**KIRKLEES METROPOLITAN COUNCIL  
INVESTMENT & REGENERATION SERVICE**

**DELEGATED DECISION TO DETERMINE PLANNING APPLICATIONS**

Reference No:	<b>2024/62/90342/W</b>
Site Address:	8, Boulder Gate, Marsden, Huddersfield, HD7 6LJ
Description:	Erection of single storey rear extension with roof terrace above, external alterations and extension of existing garage
Recommending Officer:	Lucy Taylor

## **Officer Report.**

Job No: 02223 Drawing No: 02223/PP/02/R02

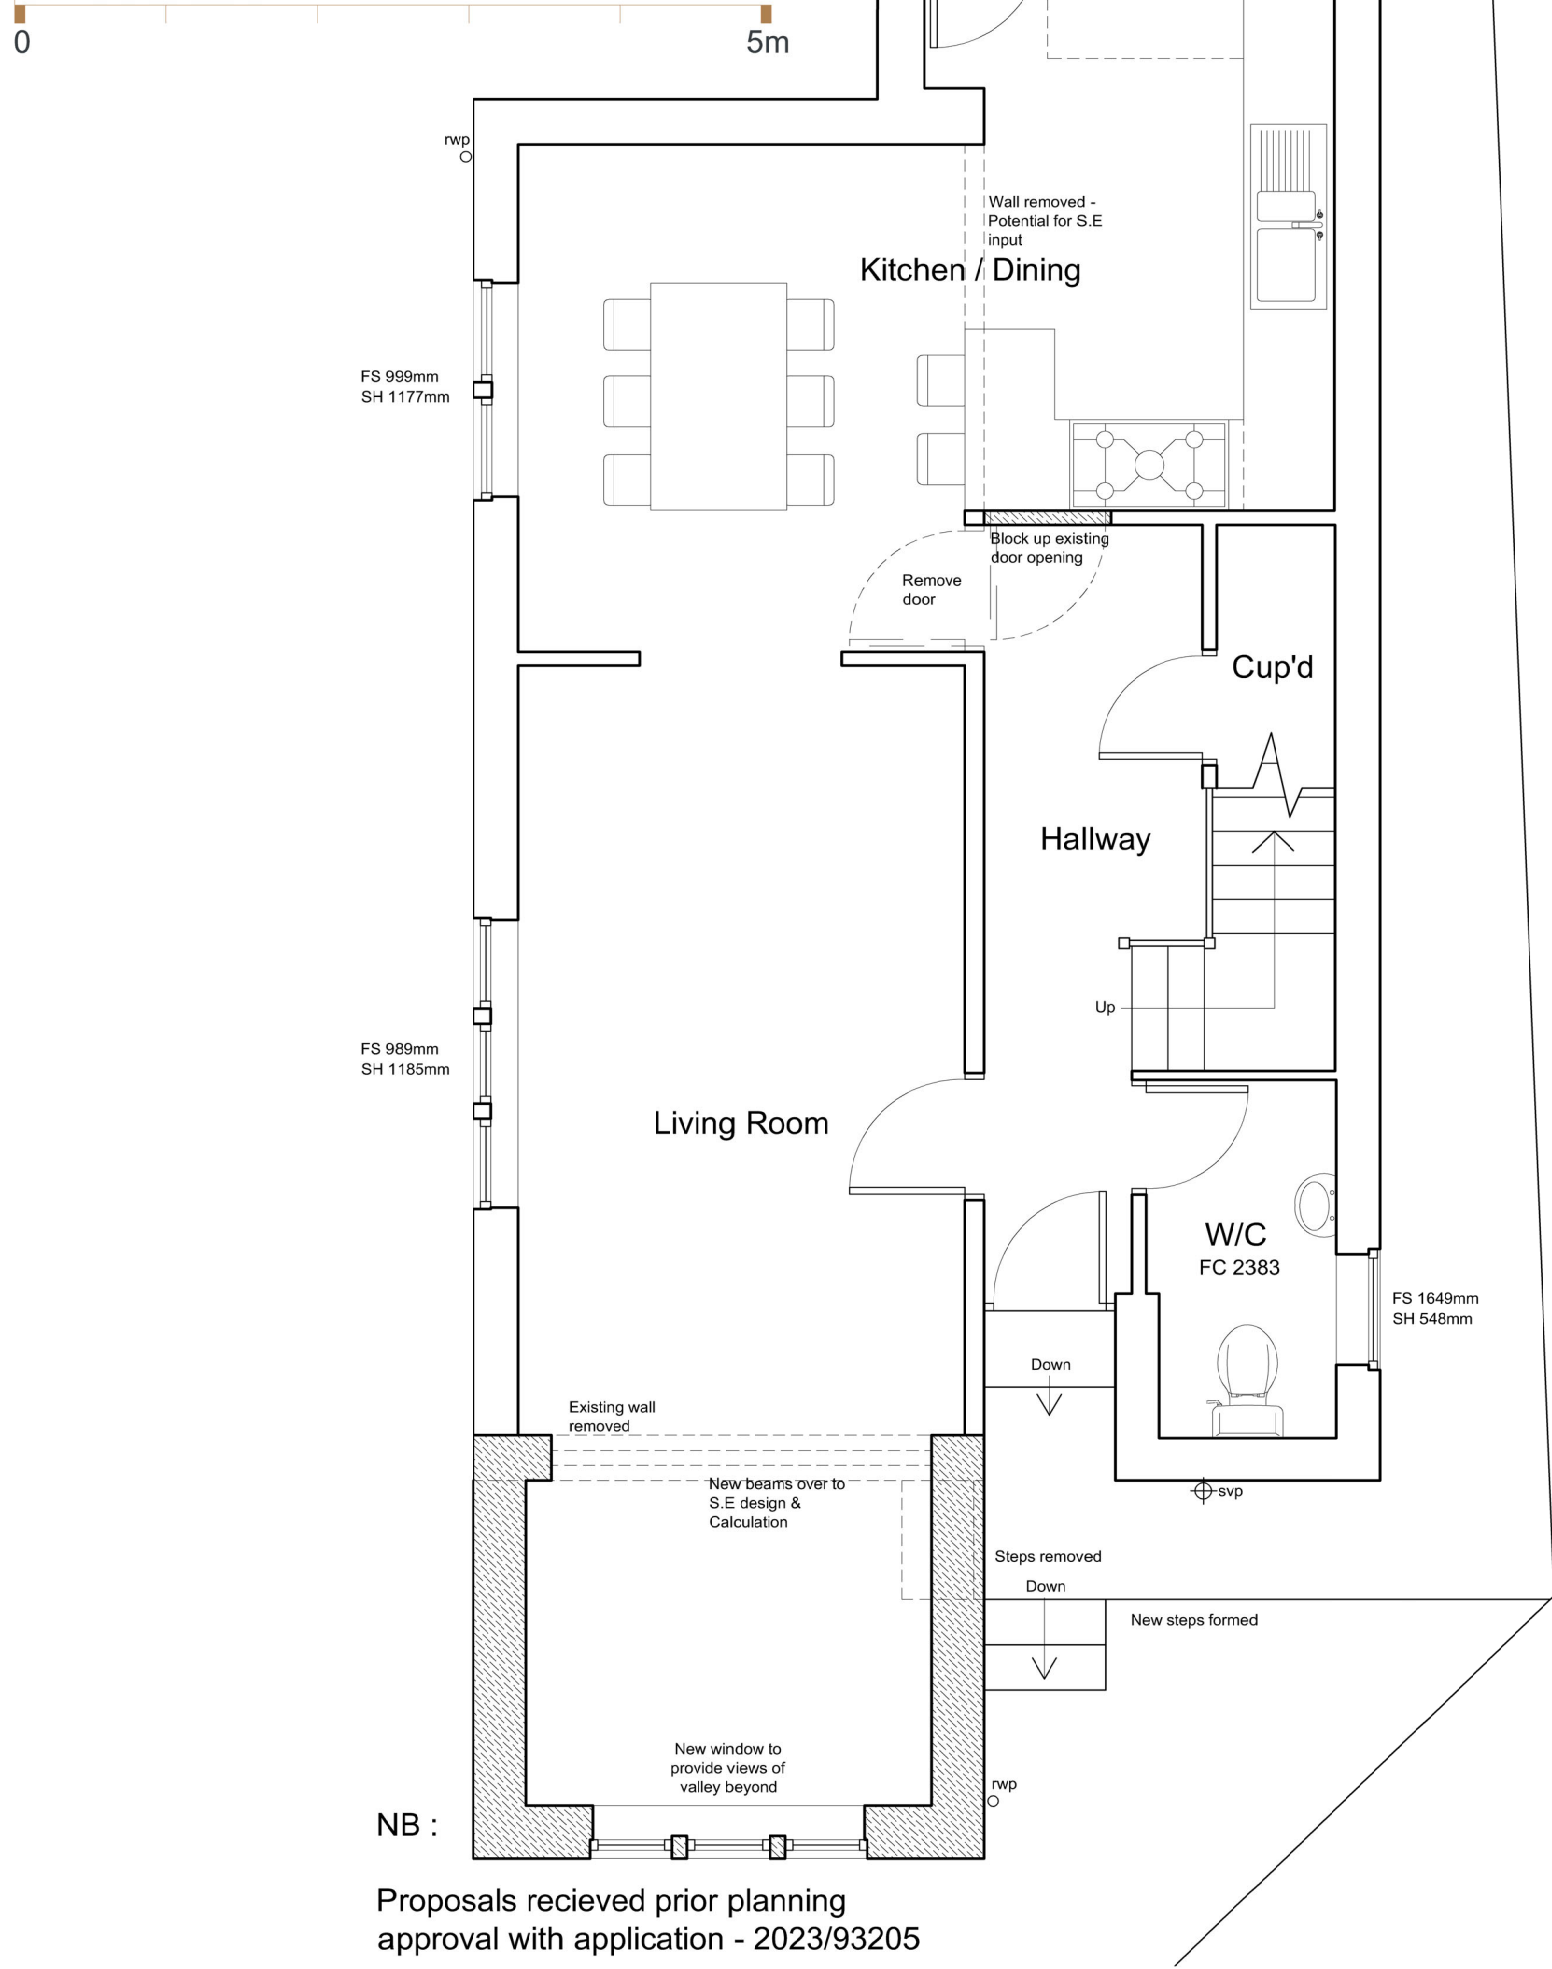
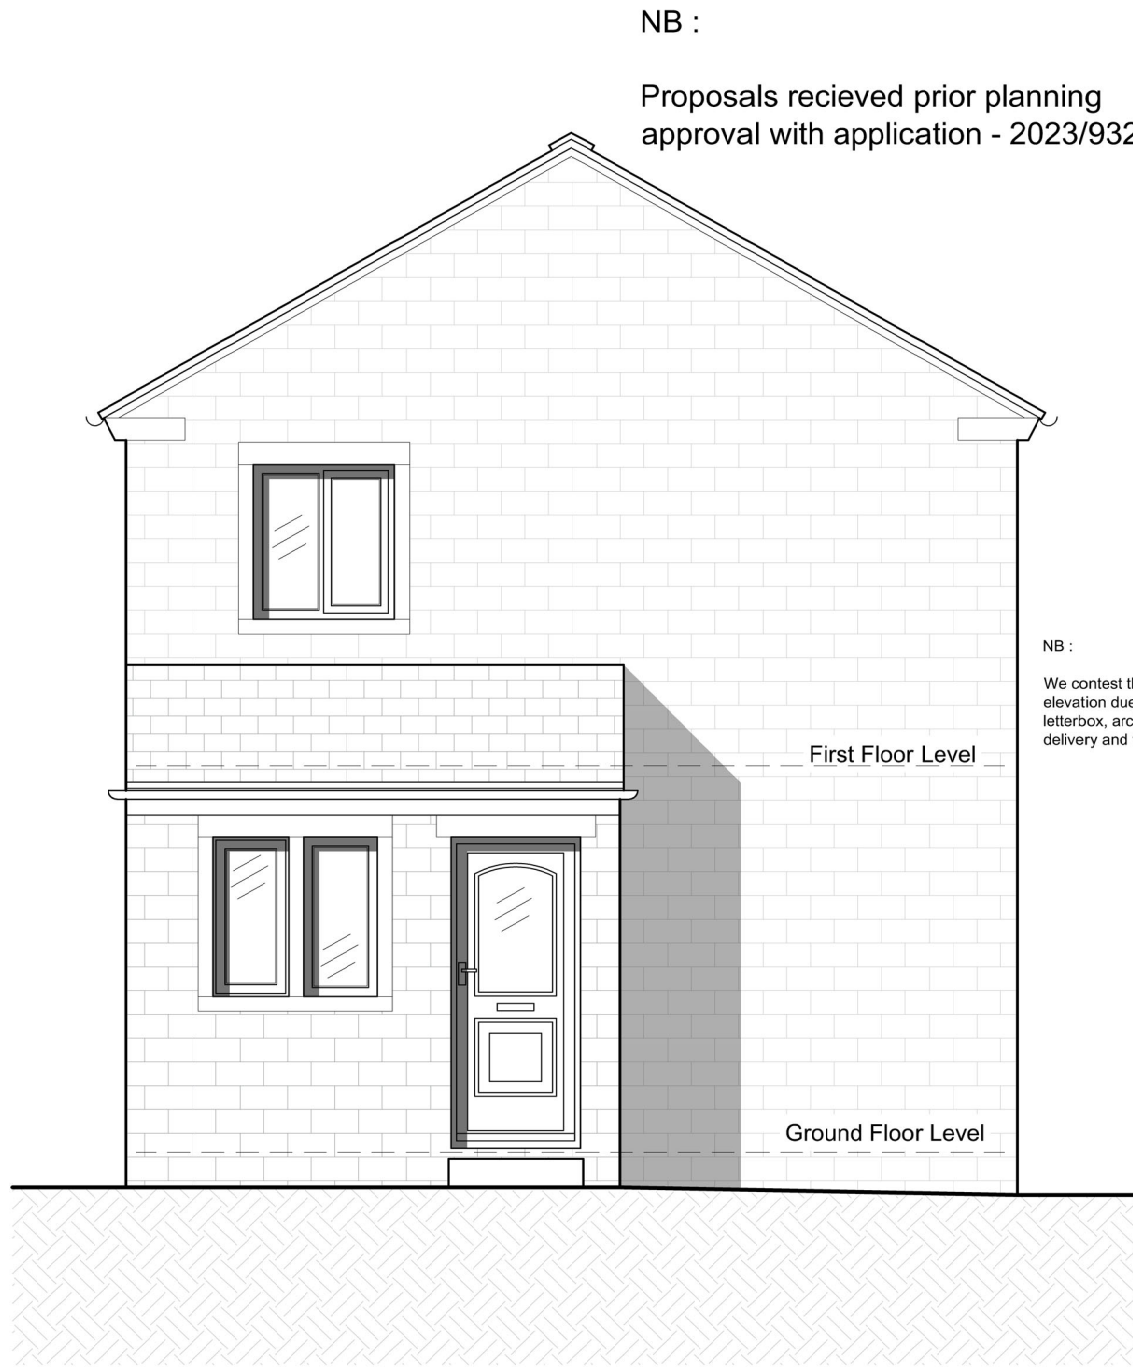
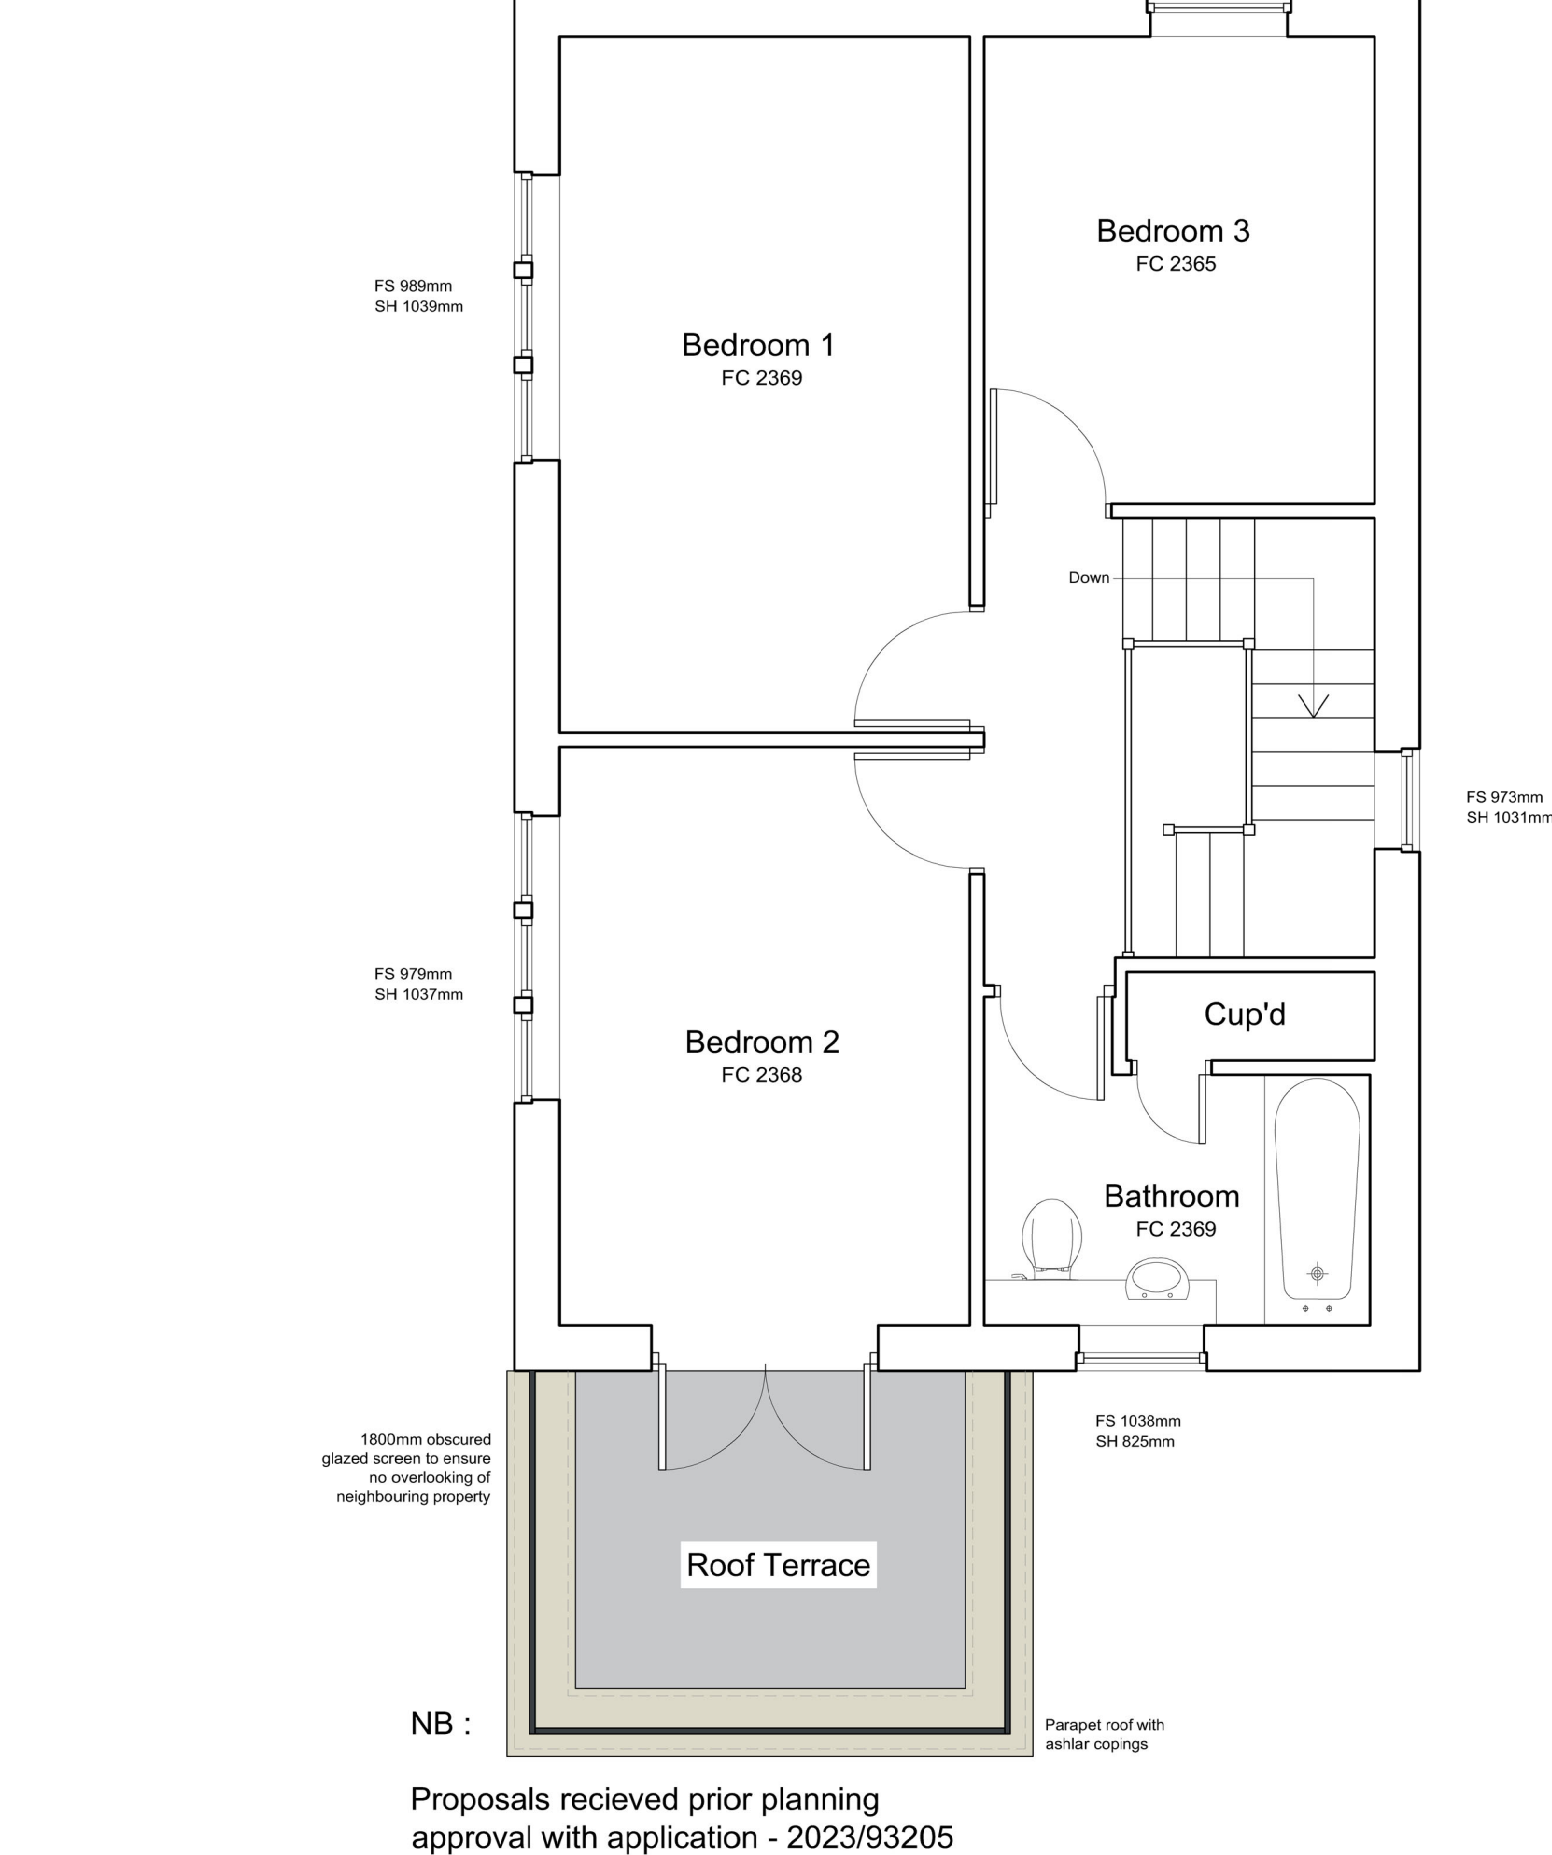
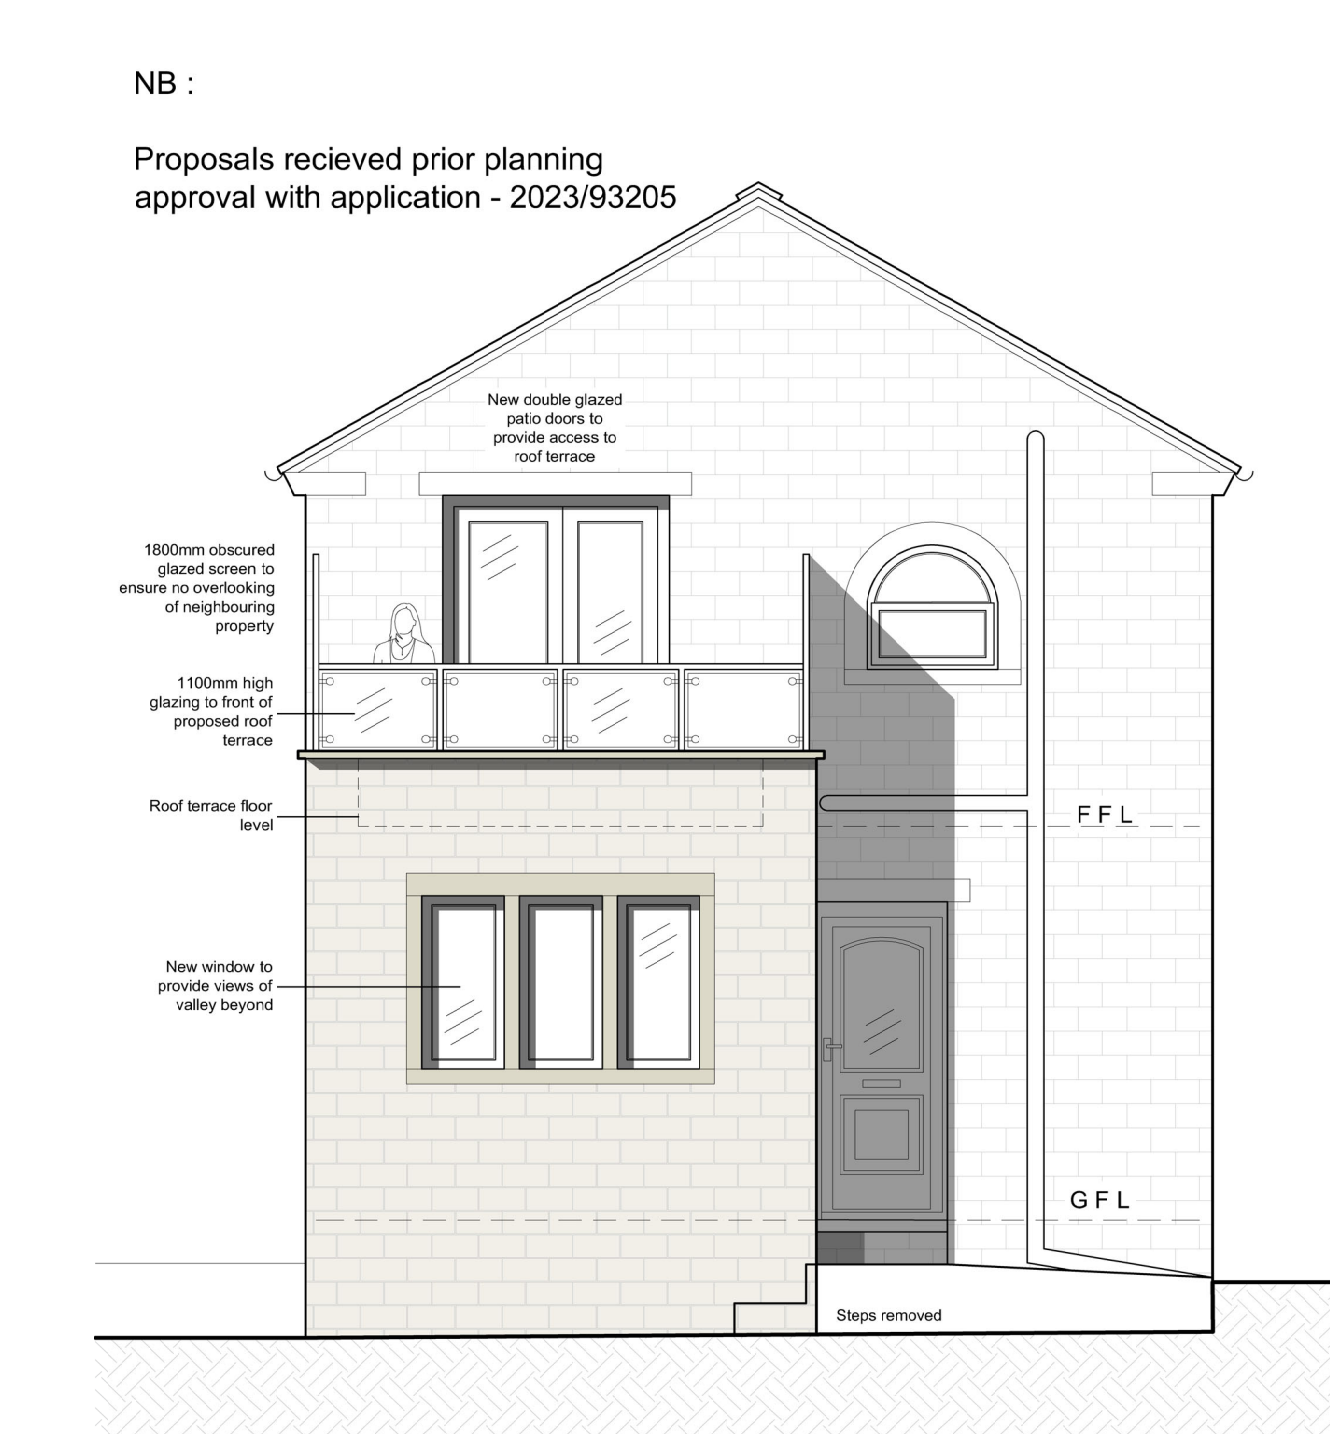
The proposed extension would have a projection of 2.5 metres, with a width of 3.4 metres and a height of 3.85 metres. The extension would be faced in coursed stone.

The roof terrace would be above the flat roof of the extension, with 1.1 metres high glazed balustrade to the front elevation and 1.8 metres high privacy screen to both side elevations. New double glazed patio doors are to be installed to the host property to provide access to roof terrace.

The host property of 8 Boulder Gate is detached, and the extension would have a projection of 2.5 metres, with a height of 3.85 metres. These dimensions are considered to result in an extension which would not cover more than half the total area around the original house and would be considered subservient from a visual amenity perspective. In addition, the extension would retain a minimum separation distance from any boundaries of curtilage of approximately 1.2 metres.

The proposed roof terrace would have 1.8-metre-high privacy screens to both its side elevations. The incorporation of these privacy screens is considered to be sufficient to mitigate any undue impacts of overlooking to either Cartref or No. 6 Boulder Gate and a condition to ensure they are in place before the terrace is brought into use would be included upon any grant of approval. The proposed obscure glazing would reduce the massing of the roof terrace above the ground floor extension. It is noted in objections and from observations on site that the 'open' rear boundary of the roof terrace would look towards an element of the front garden area of Cartref. However, this would be towards the driveway and then onwards to Gate Head itself. It is concluded that this outlook would not result in an undue loss of privacy or overbearing impact.

4. The roof terrace shall not be brought into use until a 1.8-metre obscure glazed privacy screen has been placed on both side elevations of the roof terrace, as shown on dwg no. 02223/PP/02/R02. The two 1.8-metre obscure glazed privacy screens shall be retained thereafter.
